**From:** Justin Turnbull  
**Sent:** Monday, January 08, 2018 3:23 PM  
**To:** Chelsea Benner  
**Cc:** Kelly Bacon; Lucas Huck  
**Subject:** RE: Woody BLA BL-17-00018

Justin and Chelsea – Attached is an preliminary map of the Woody BLA survey updated to address PW comments. The area for Sisters Road right of way is included in both the title report and tax records for the Woody property. The owner would like to clean up the right of way but concerned he keep losing acreage. He does not want to alter the south boundary of Parcel 1 that has been established. I am hoping CDS will approve this layout of 9.95 acres recognizing it is 10 acres as originally described but losing 0.05 acres to clean up the Sister Road Right of Way conflict. I added note 13 to clarify this issue.

WOODY PROPERTY

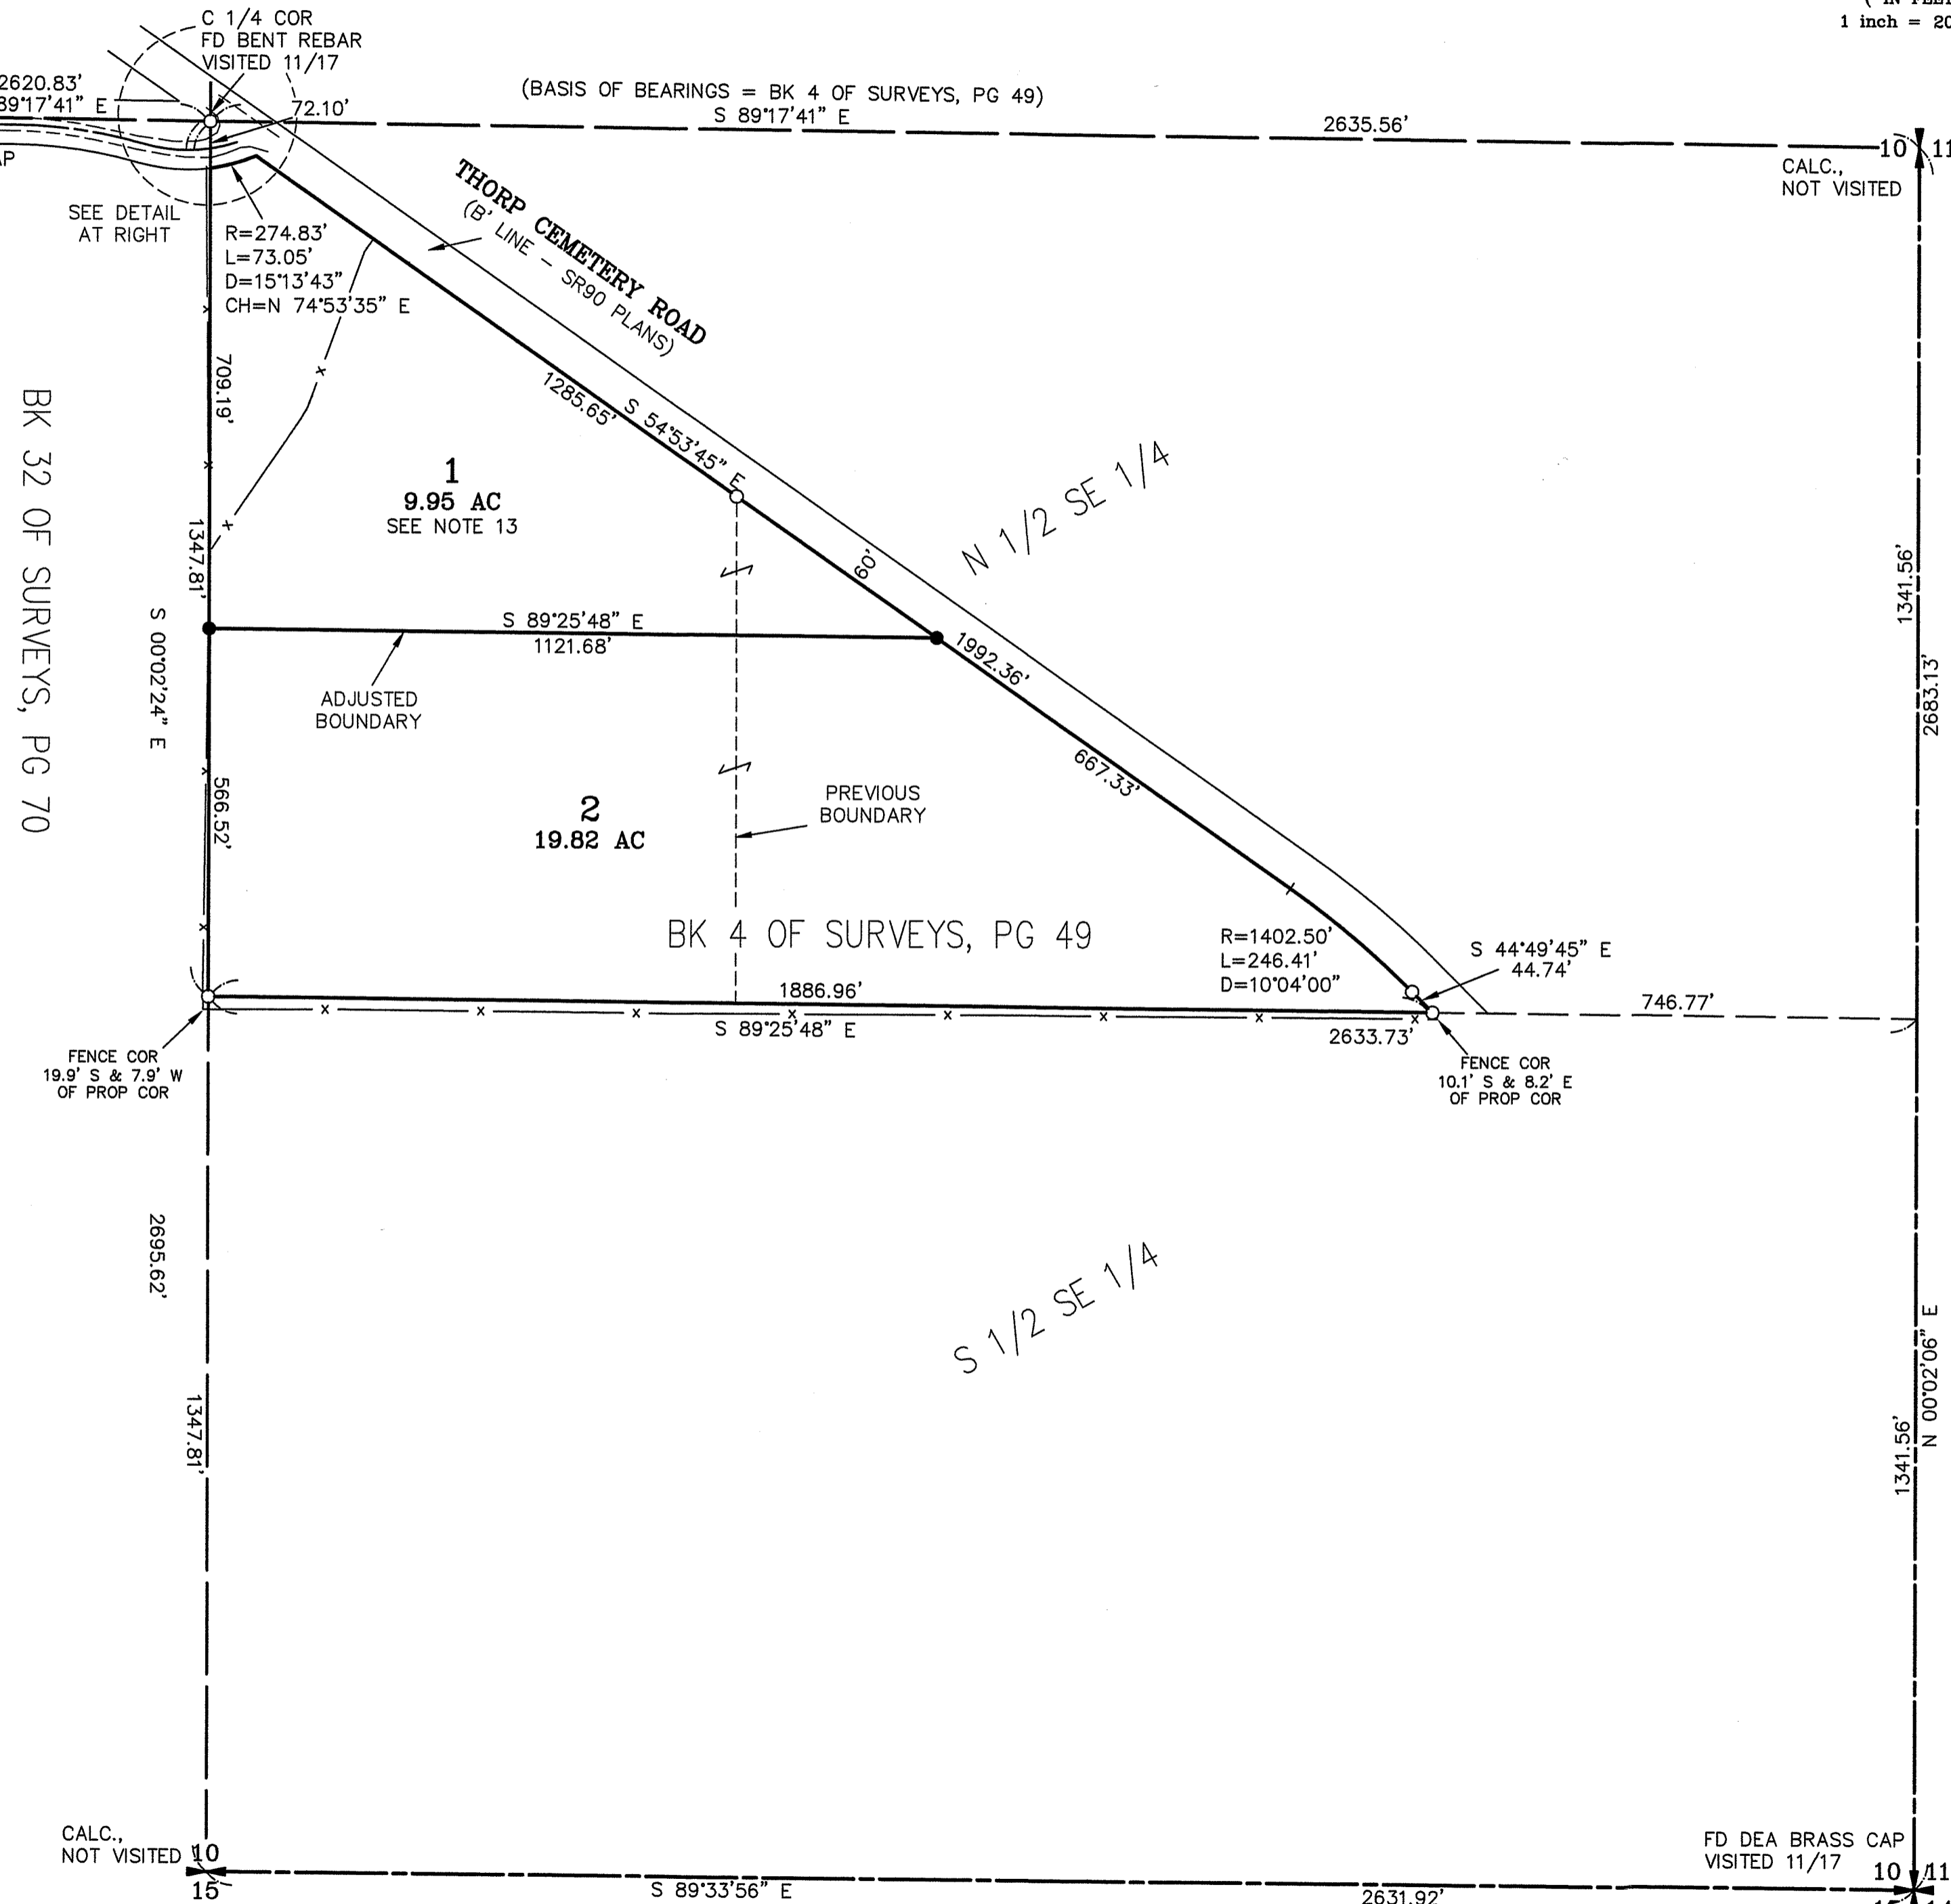
I talked this over with Lindsey and we determined that the .05 acres can come out but needs to come out of the larger parcel as that is where it originally was included.

WOODY PROPERTY

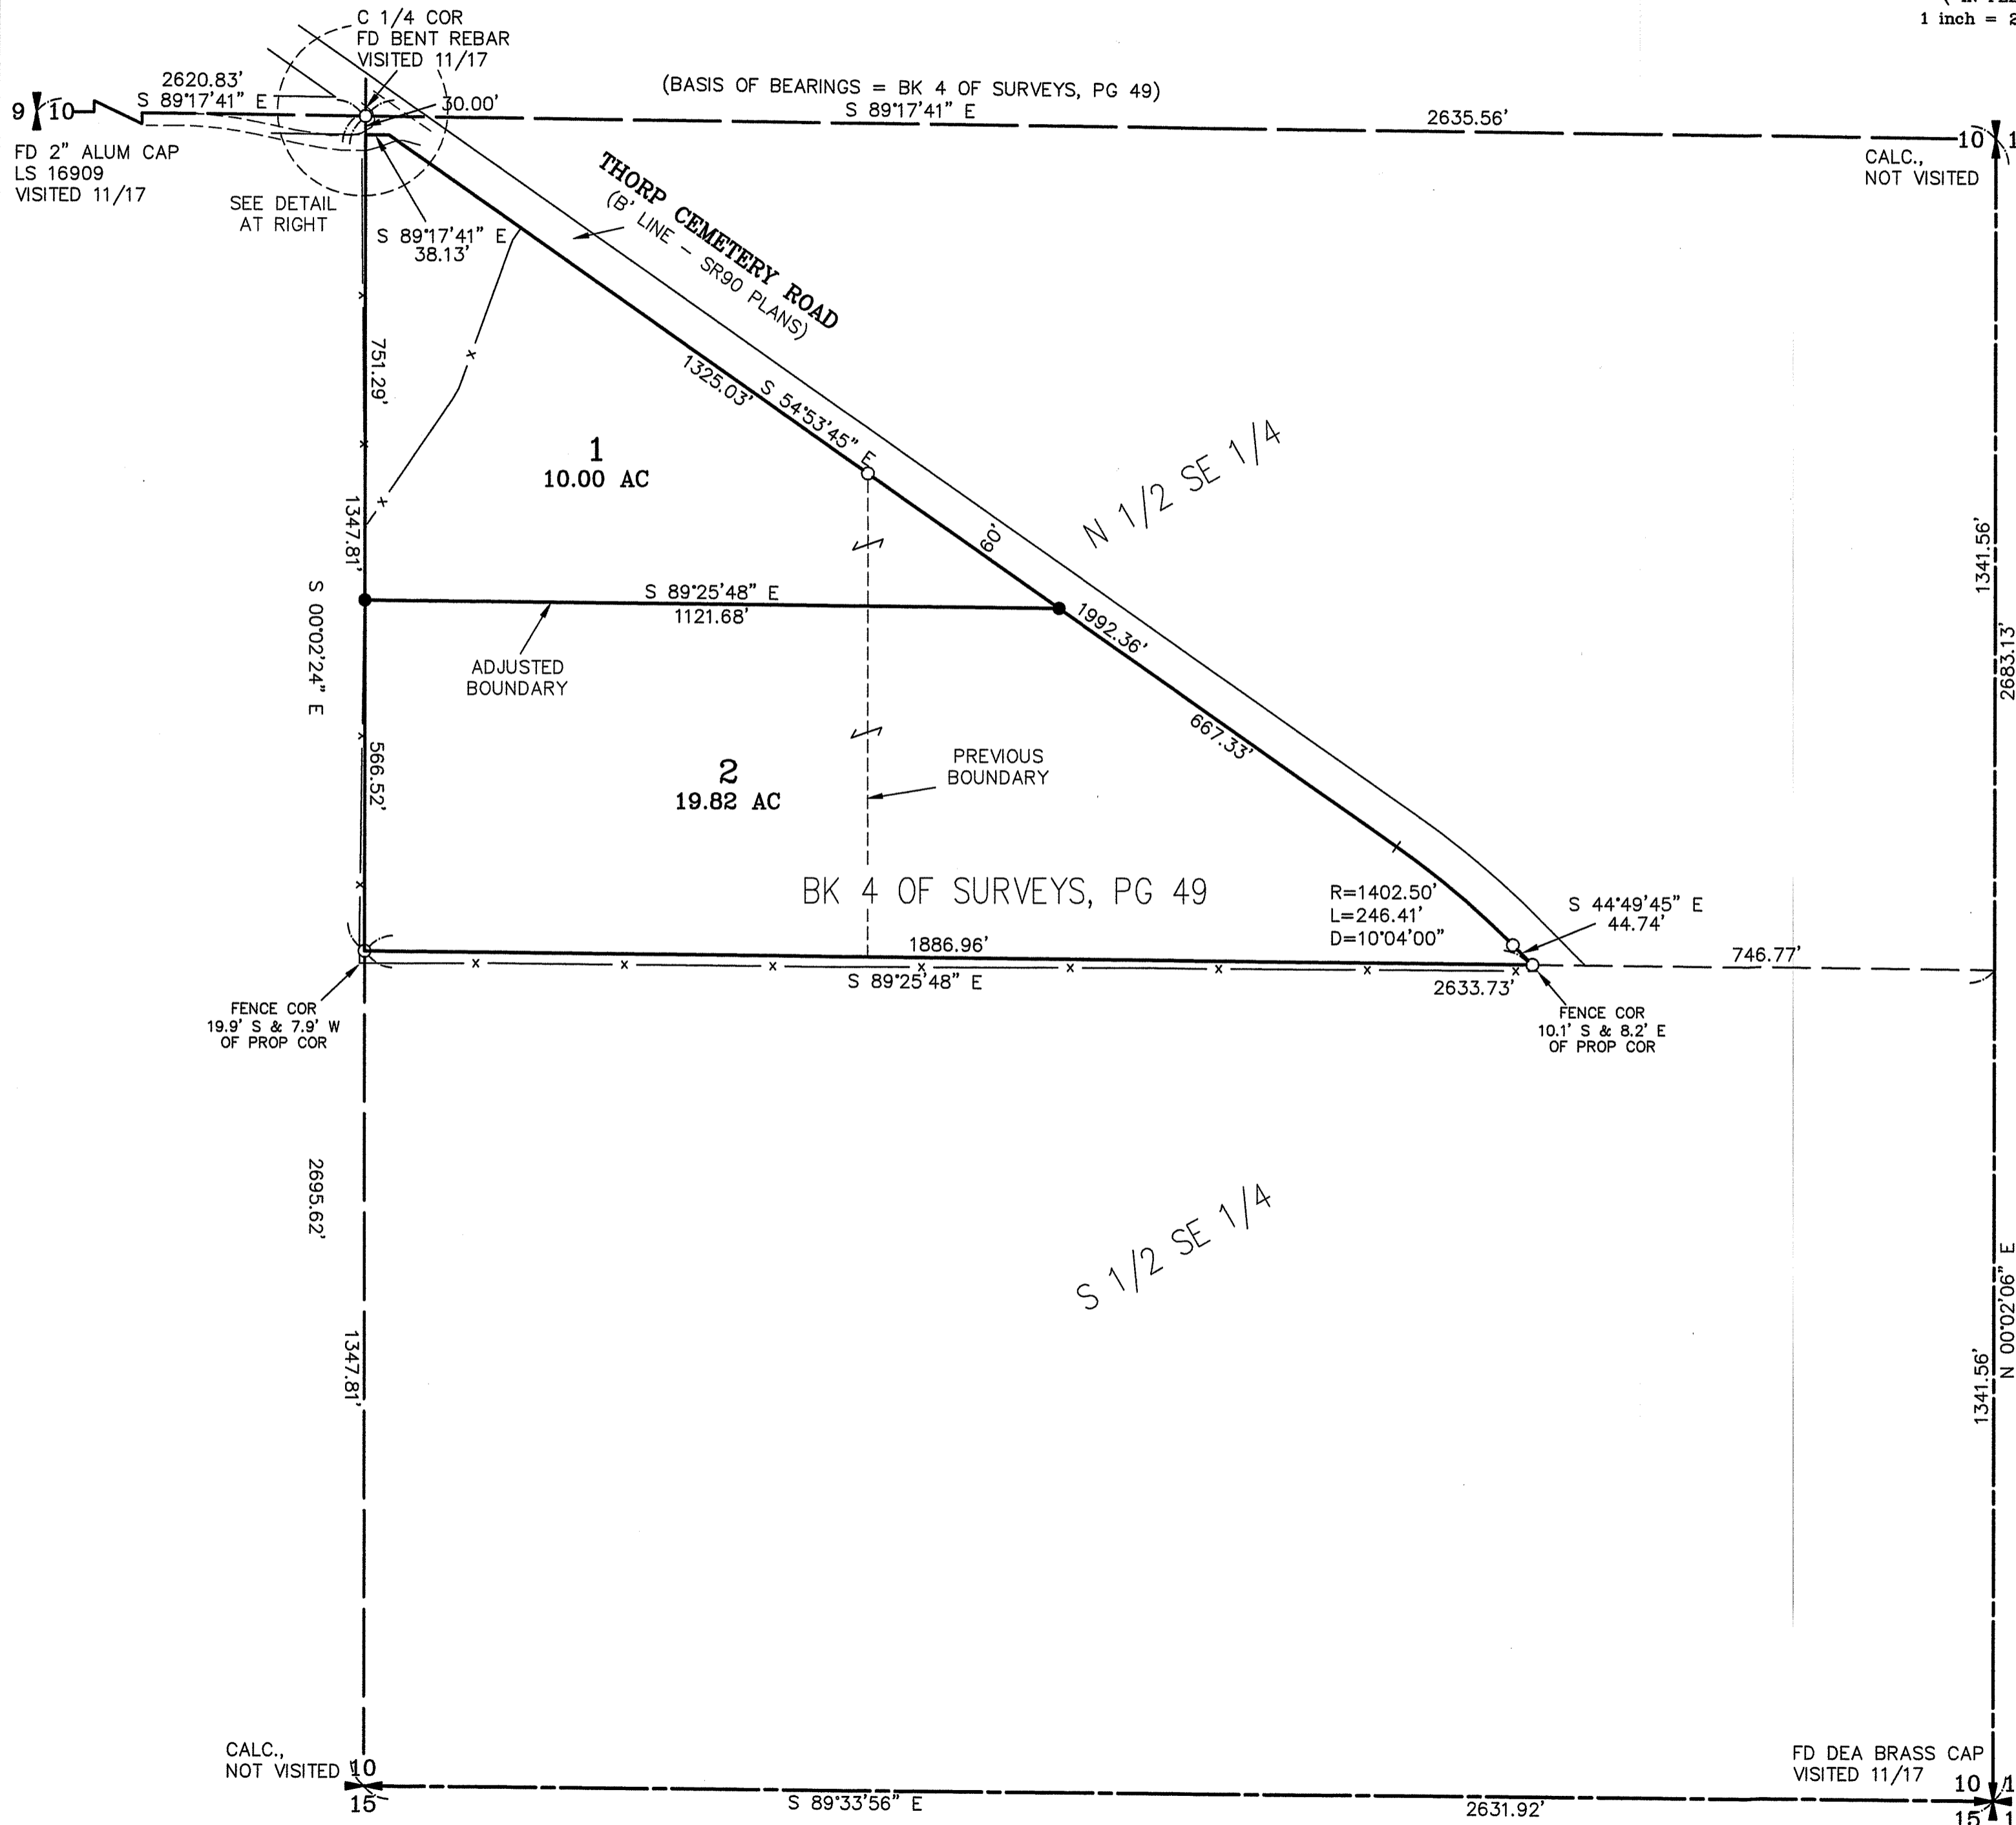
Our records fail to mathematically describe the roadway in any form. We have visual representation of the roadway for utility franchises from 2015, 2008 and 1974 all showing the road bending, and Aerial photography from 1954 show the bend in the road as occurring prior to the construction of I-90.

Sunquist performed an adjacent survey in 2007 and shows the roadway clearly bending and holds the roadway as not being centered about the section line..

From my records, the lack of documents creating the roadway (deeds or road grants), combined with the long history of the road bending, leads me to lean towards centering the Right of way about the existing roadway, and holding a 60' R/W by prescription per RCW:36.75.070.

It appears that the only survey in disagreement with this is Skinners survey from 1977.

If Parcel 1 needs to be 10 acres I will add the right of way back into the parcel and address the Sisters Road right of way conflict with a note. Please review and contact me back with any questions/concerns or notice to proceed and we will record.
